Re: Application to discharge planning condition 2 of Application Ref: 13681/22

Planning Portal Ref: PP-12968433

This application to discharge Condition 2 being resubmitted in response to Decision Notice 16885/23 which refused the discharge of the condition.

H3C Headwall

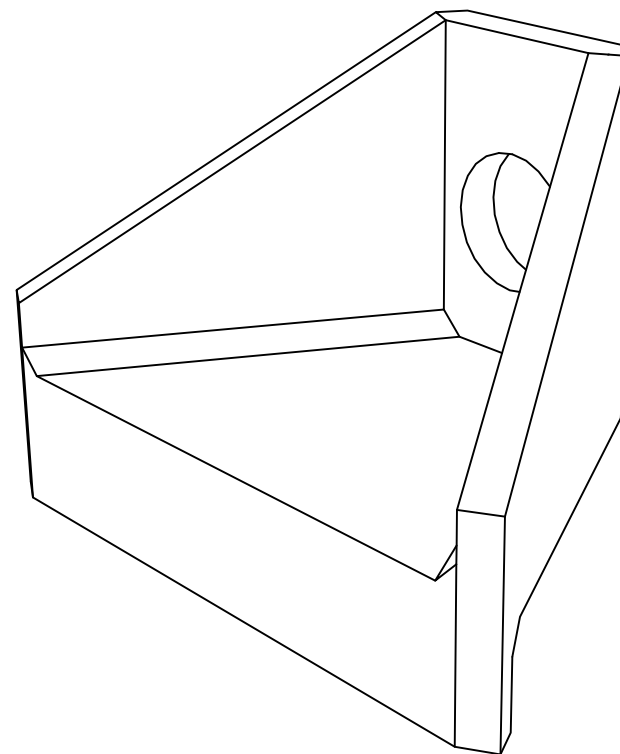
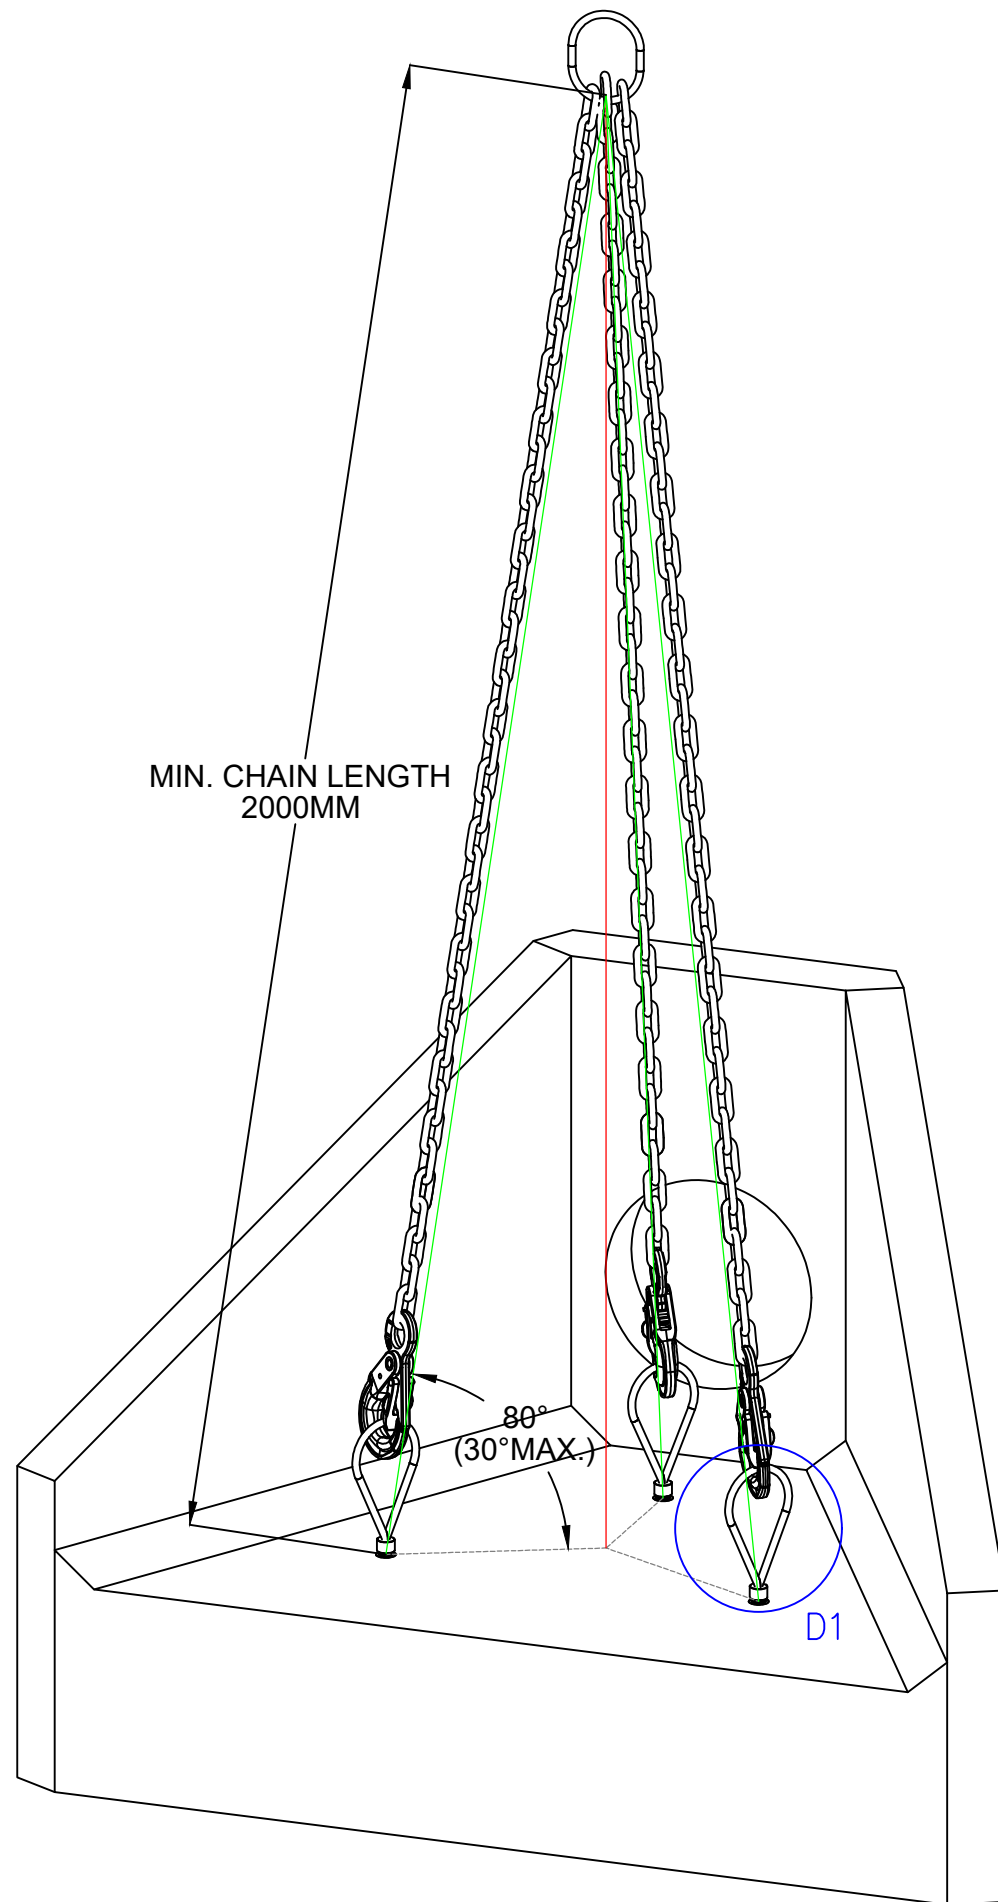
- b) Considering the outlets/inlets for the swales/basins, what is the construction arrangement to protect the submission for 16884/23 (the plans submitted for 16885/23 do not match those for 16884/23)?

We are proposing to protect the headwalls with the approved detail shown on drawing NS/MAN/BTD/04 Rev A, "3.6m of 1.8m Standard Closeboard Fence & 1.2m Post & Rail Fence", revision dated 25.11.20. This is an approved drawing under the reserved matters approval. As set out in our approved drainage and management strategy these will be maintained by our management company.

Date: 2.11.22 Scale: 1/500 Drawn: DMH
DRAWING No: 22108/104/1 Rev: F

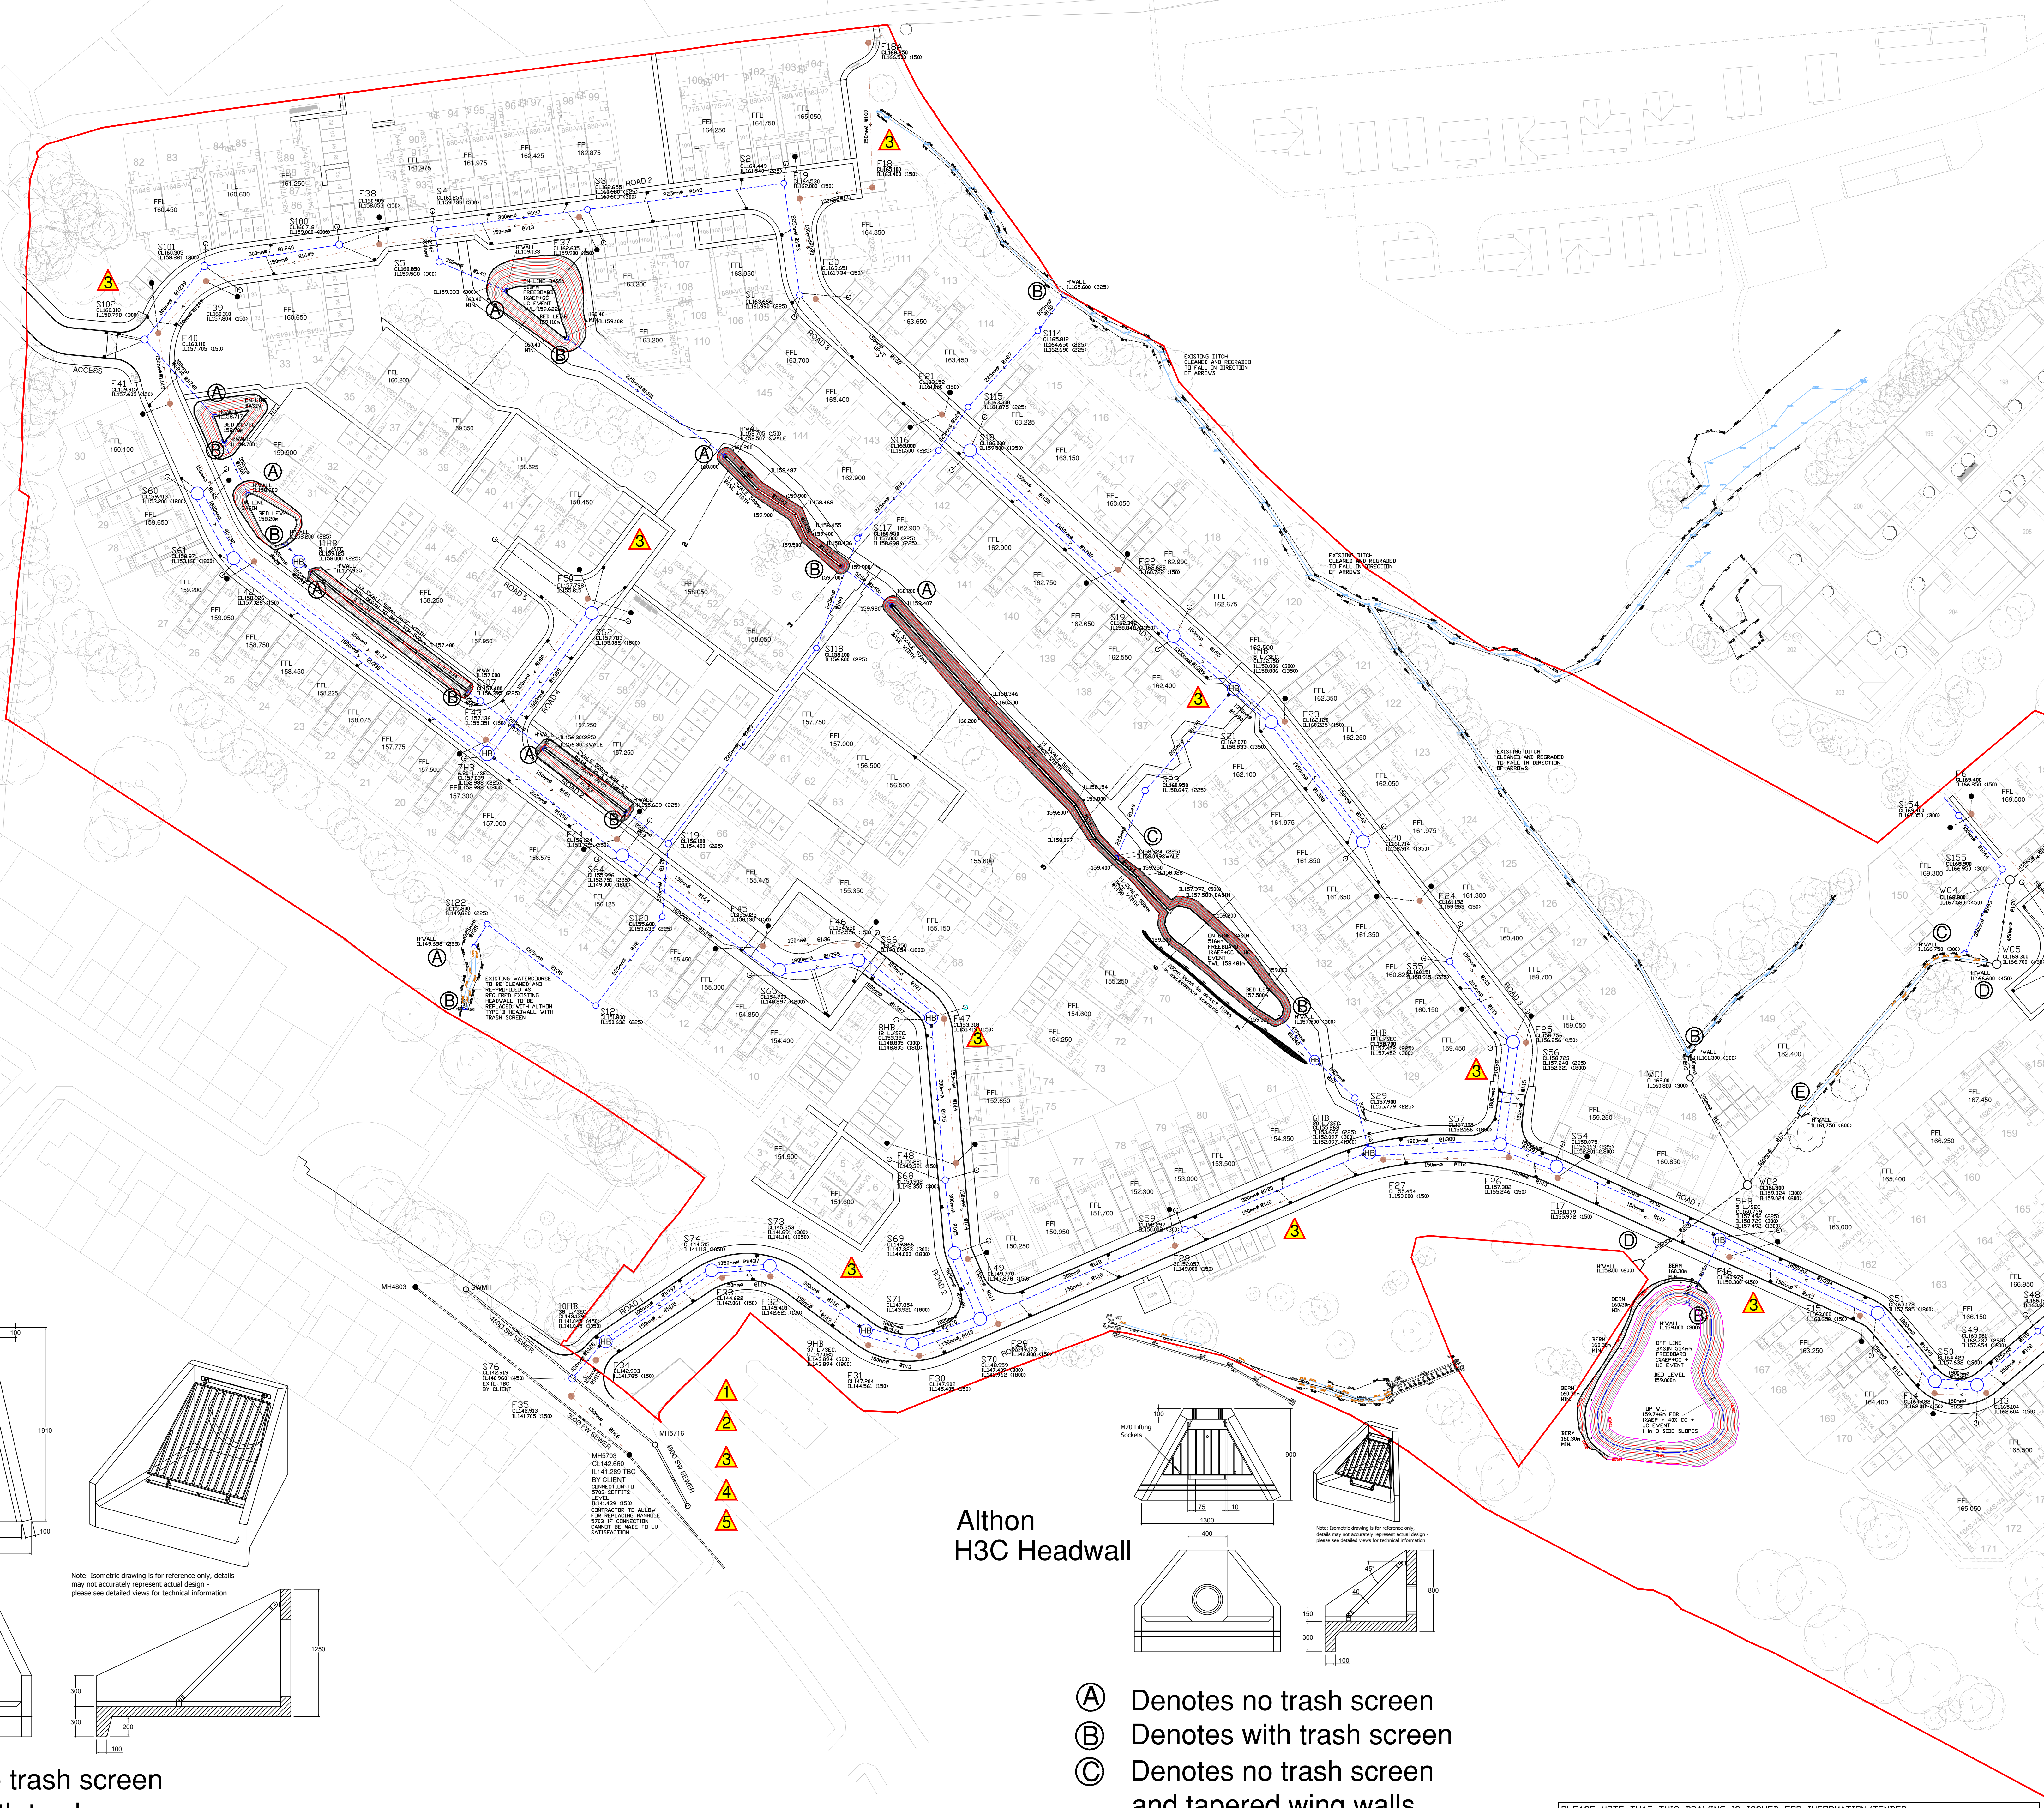
- ii) Details of debris screens to protect the entrances where ditches, swales and pipes connect
 - a) With the exception of Section R-R, it is unclear where the debris screens are being proposed. None of the other sections are annotated as such. If there are further debris screens that are being proposed then these need annotating as such on the drawing(s)...

c) Details of the debris screens have not been submitted, however, these details are shown on drawings submitted for 16884/23.

Debris screens are shown on the road and main drainage design layout, along with the location of where each debris screen is used. See supporting document reference - 104 ROAD AND MAIN DRAINAGE DESIGN-LAYOUT 104-1F and 2F, prepared by REFA.

These are shown on the road and main drainage design layout. See supporting document reference: 22108/104/1 REV F & 22108/104/2 REV F.

e) Considering the existing ditches to the north along the tree line - what is the intended width and depth of re-grading the applicant is expecting to undertake?

We are expecting to undertake minimal works in these areas. We will ensure the ditches fall in the correct direction and channel bases will be formalised and cleaned out to remove any debris. Please see drawings 22108/104/1 and 22108/104/2 Rev F.

We are not proposing to form any additional slopes in these relatively inaccessible areas, however as with all these areas they are to be maintained by our management company going forward in accordance with the previously submitted Drainage and Management Strategy.
